Haweswater Aqueduct Resilience Programme, Marl Hill Section

**Ecology Comments on Planning Application 3/2021/0661
(Ribble Valley Borough Council)**

**John Jones
Senior Ecologist
Design & Construction Service
Lancashire County Council**

28th September 2021

FIGURE 7.7

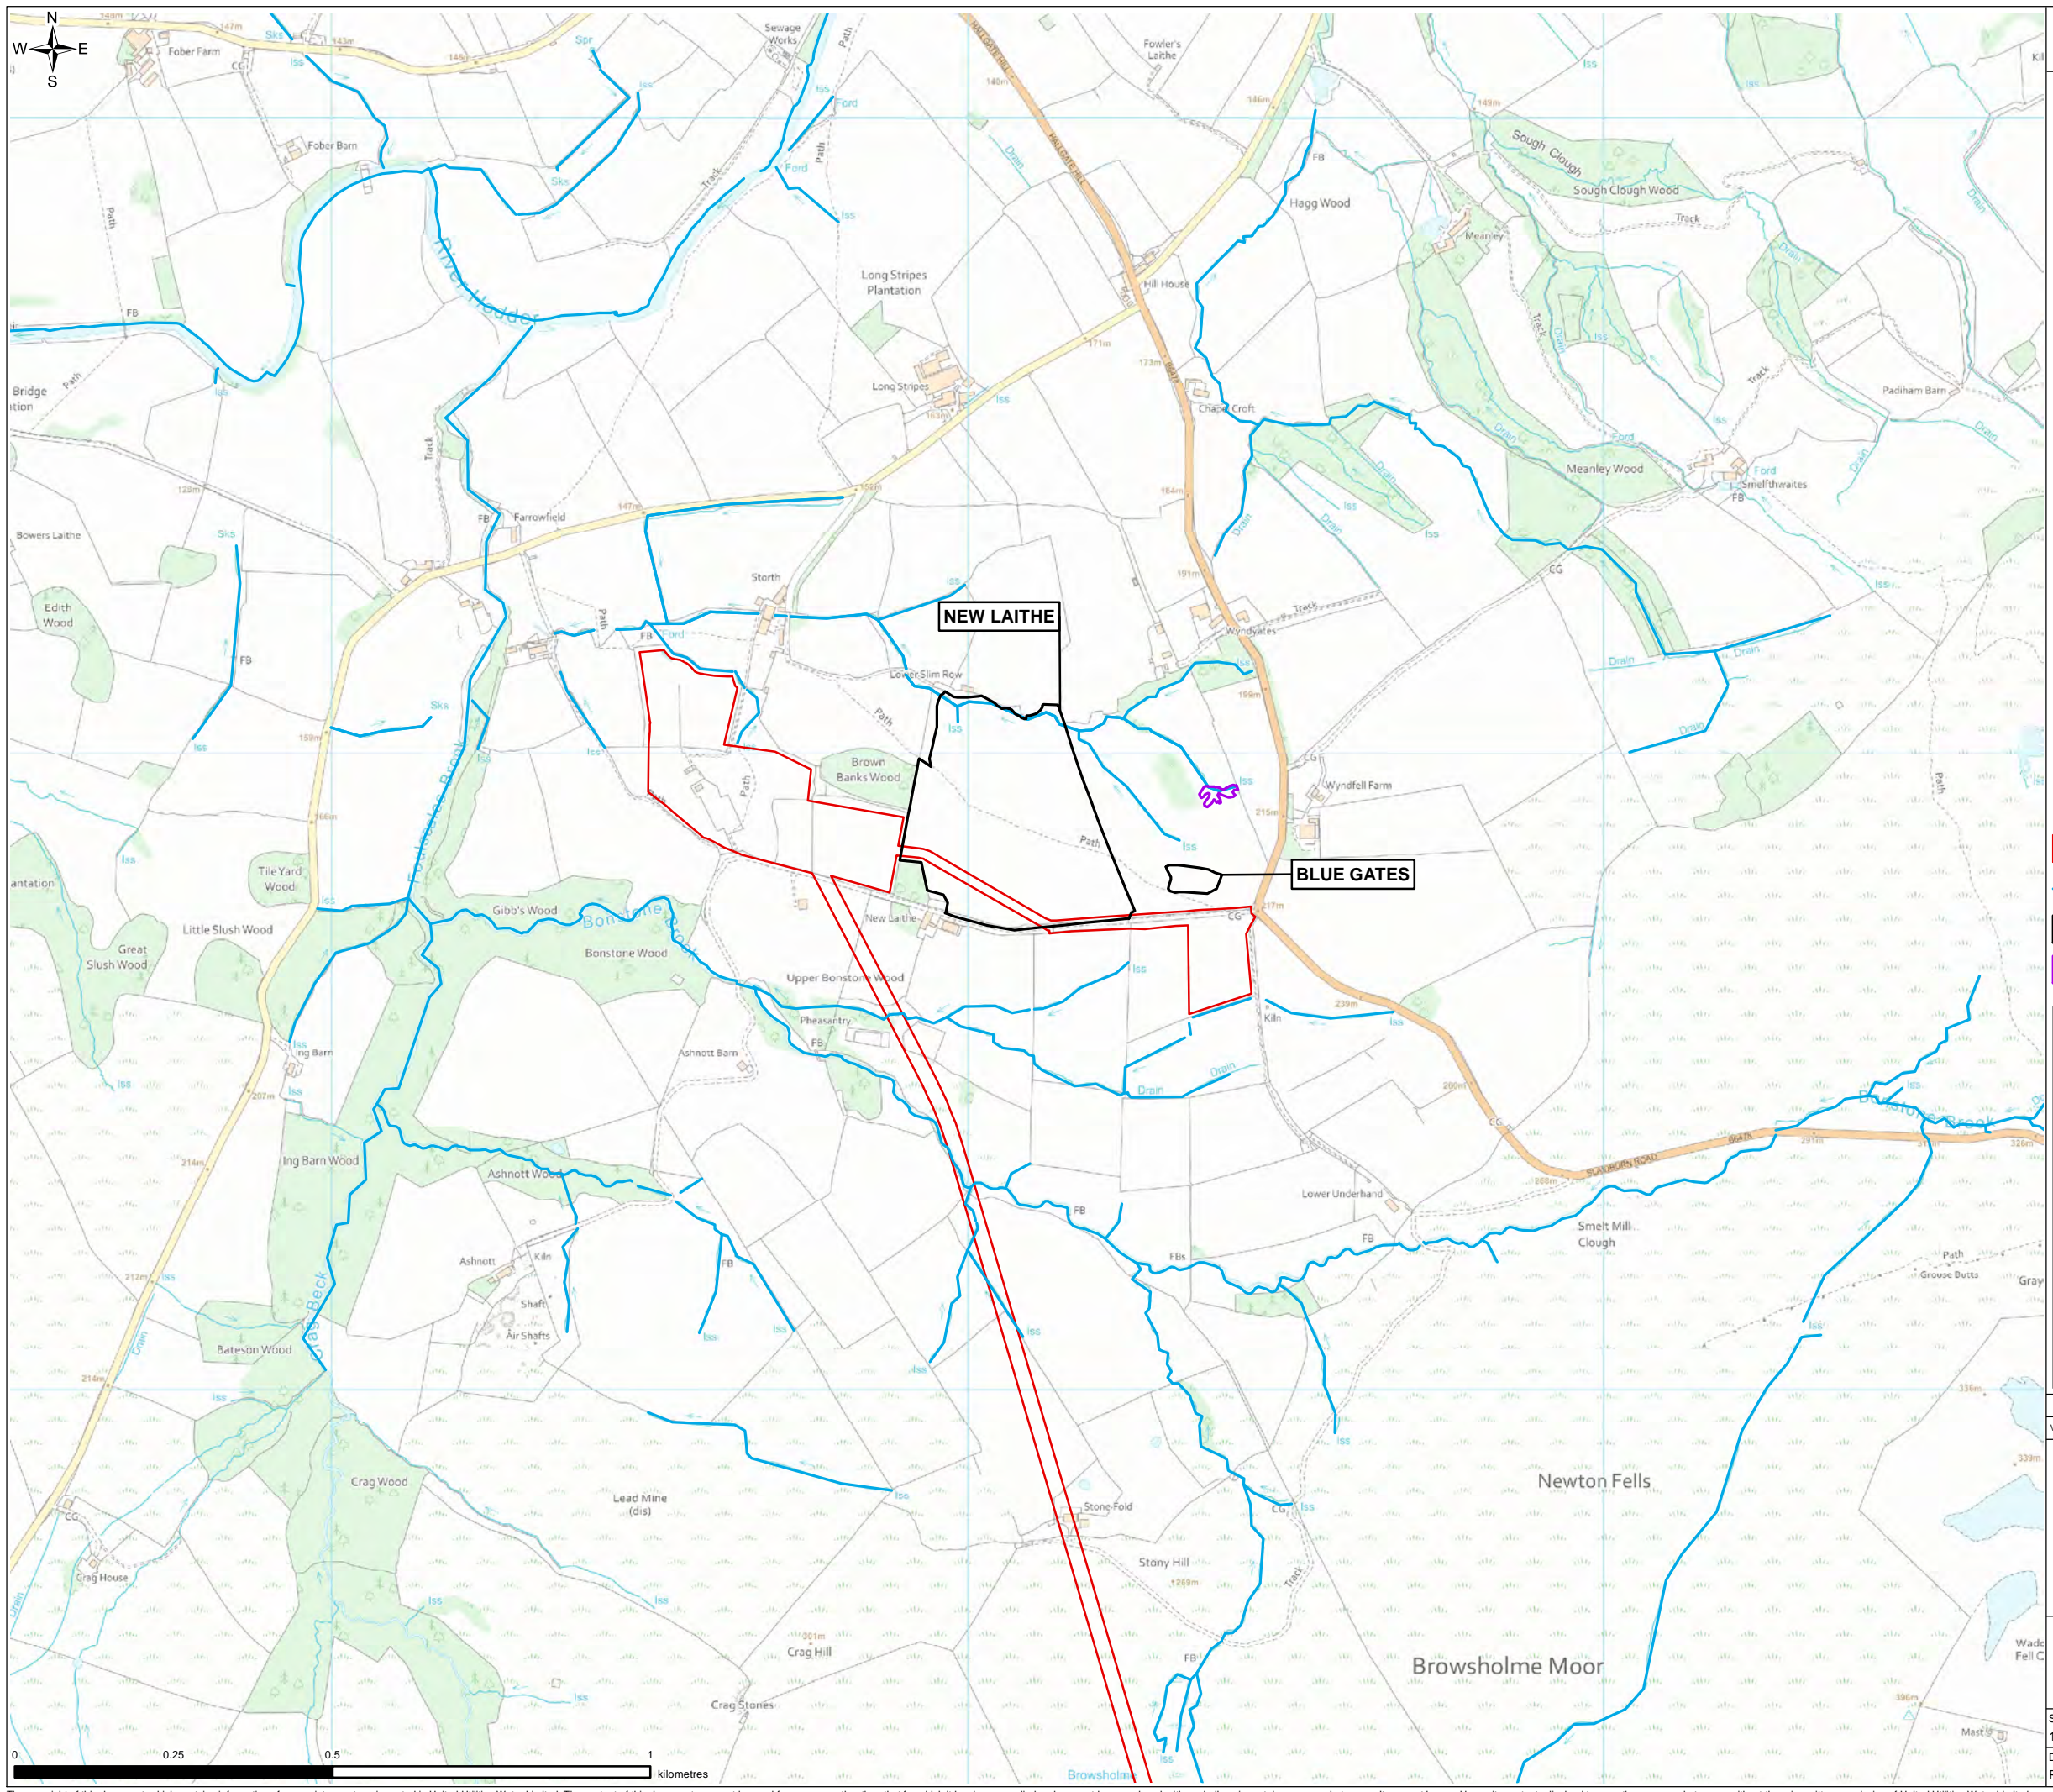
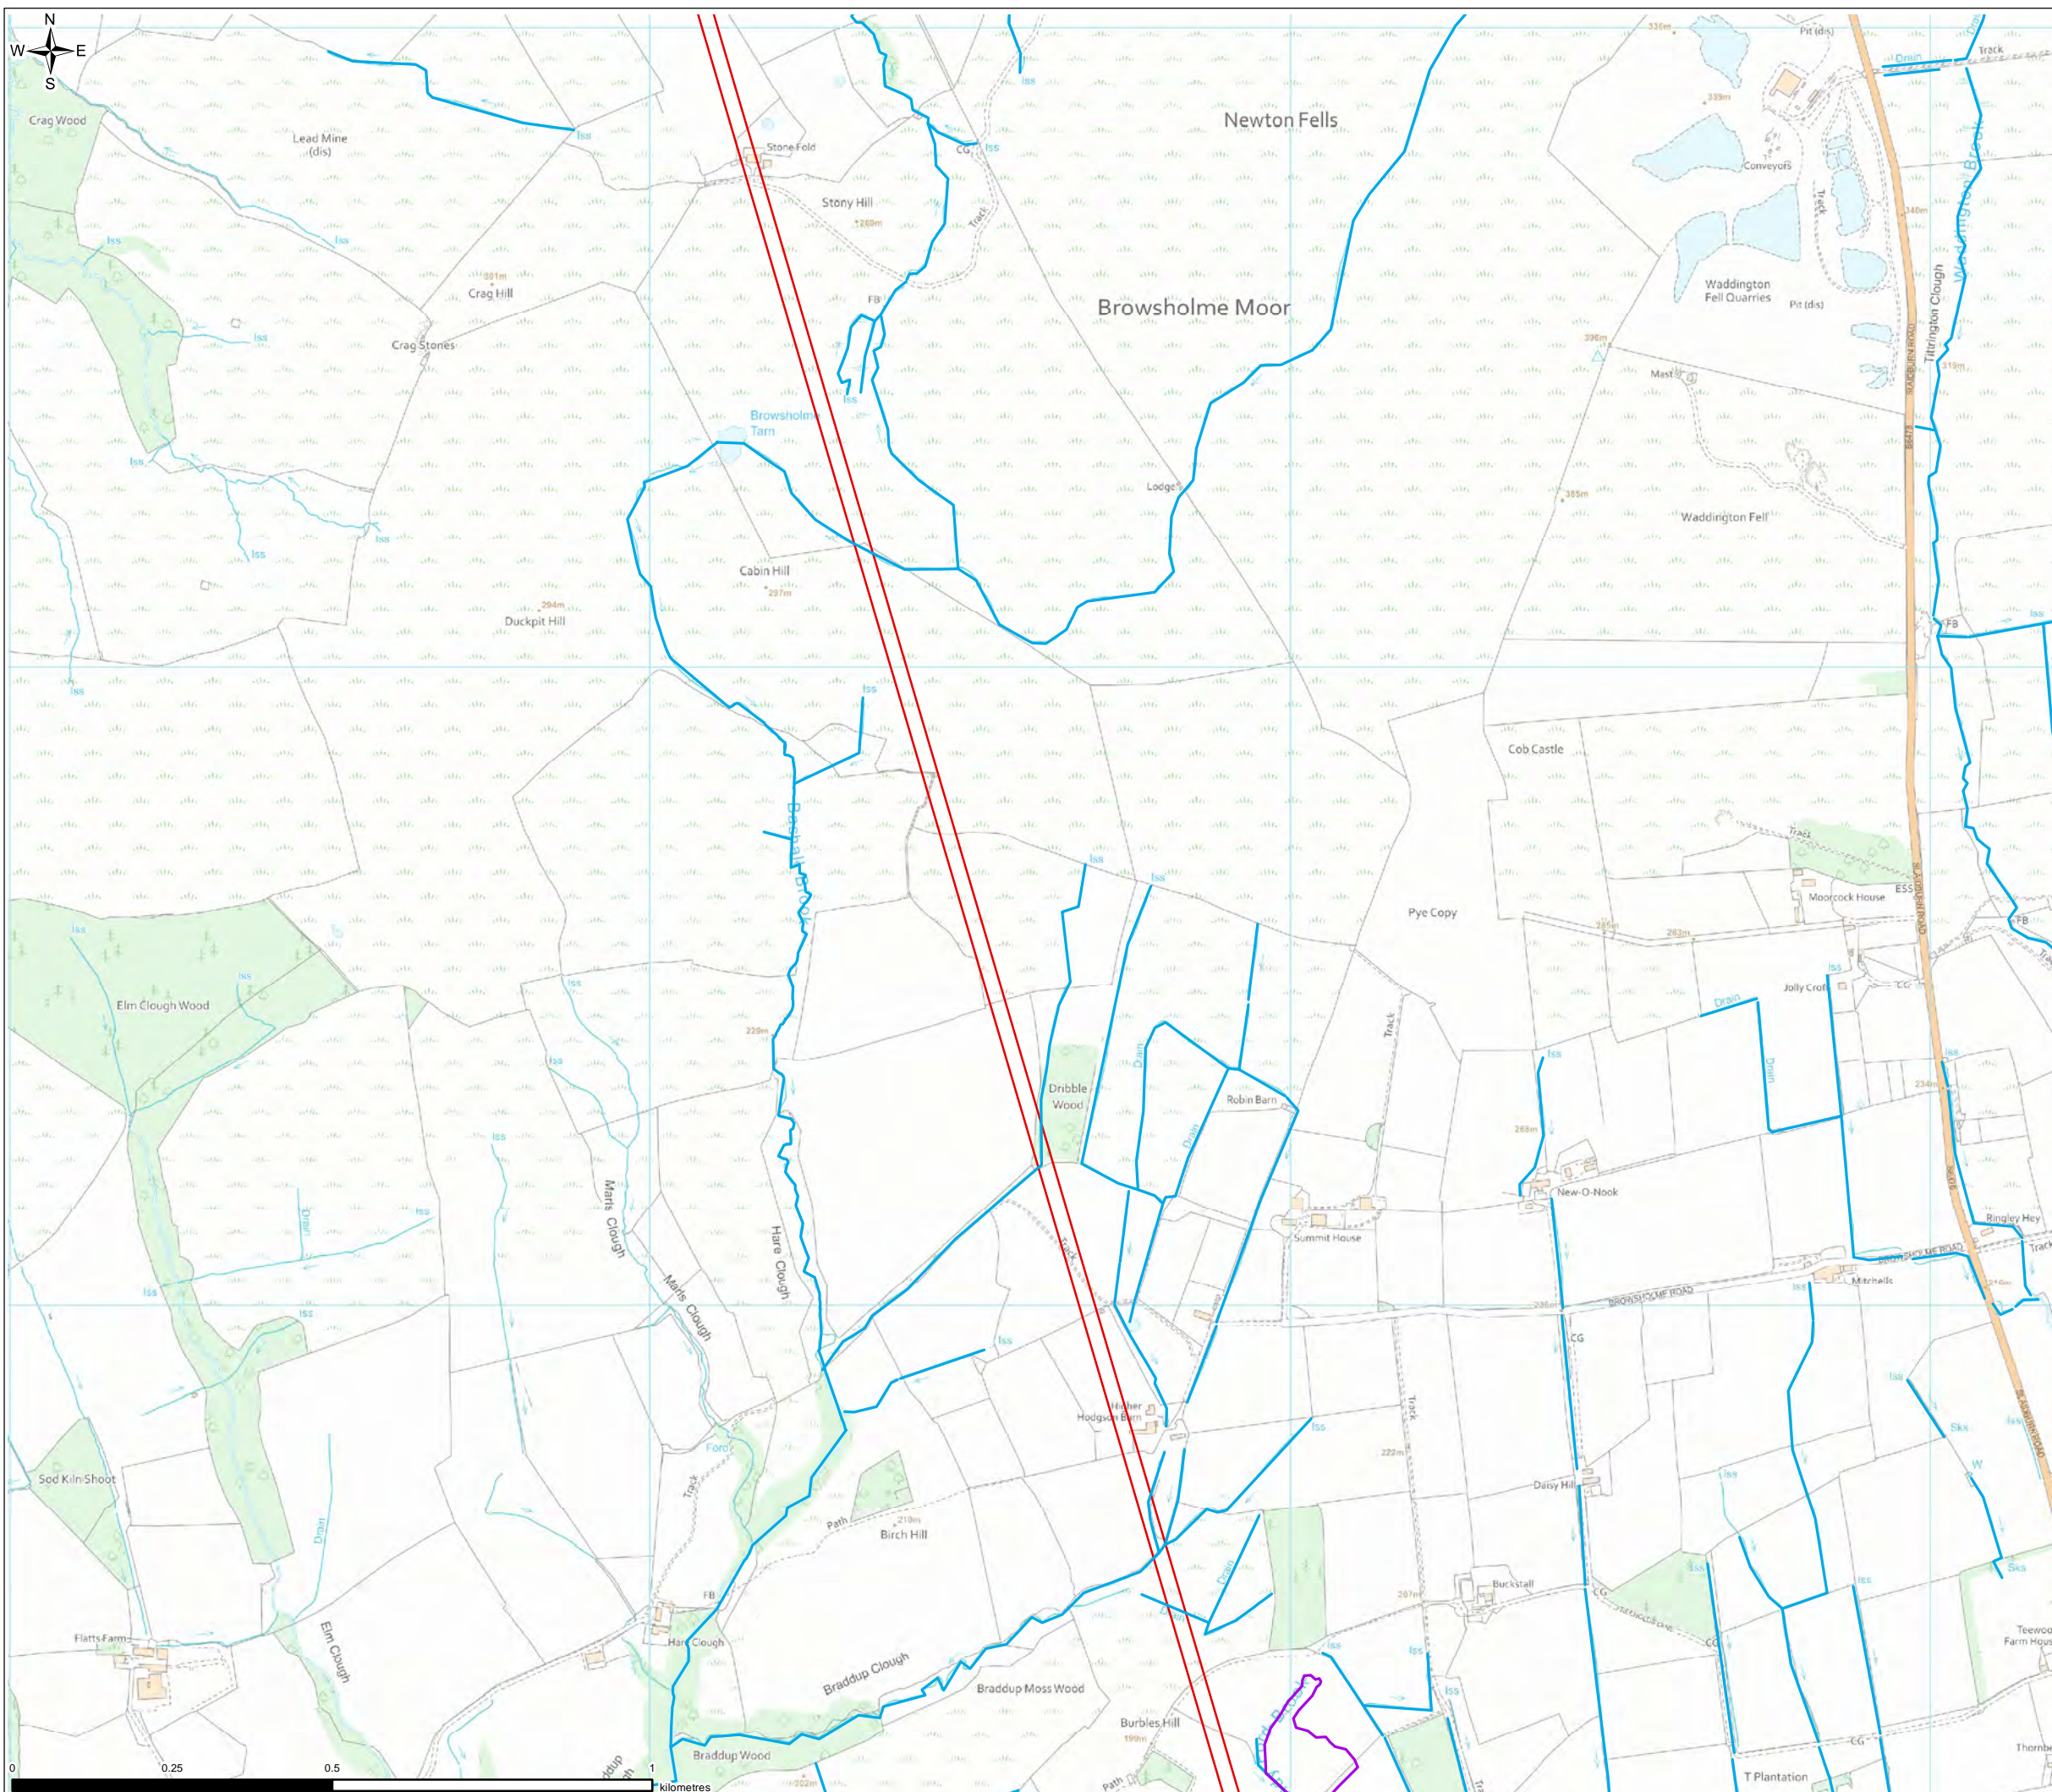
- Insufficient information to demonstrate that impacts on veteran trees are unavoidable and that a suitable compensation strategy exists.
- The assessment of impacts on groundwater dependent terrestrial ecosystems does not appear to be complete.
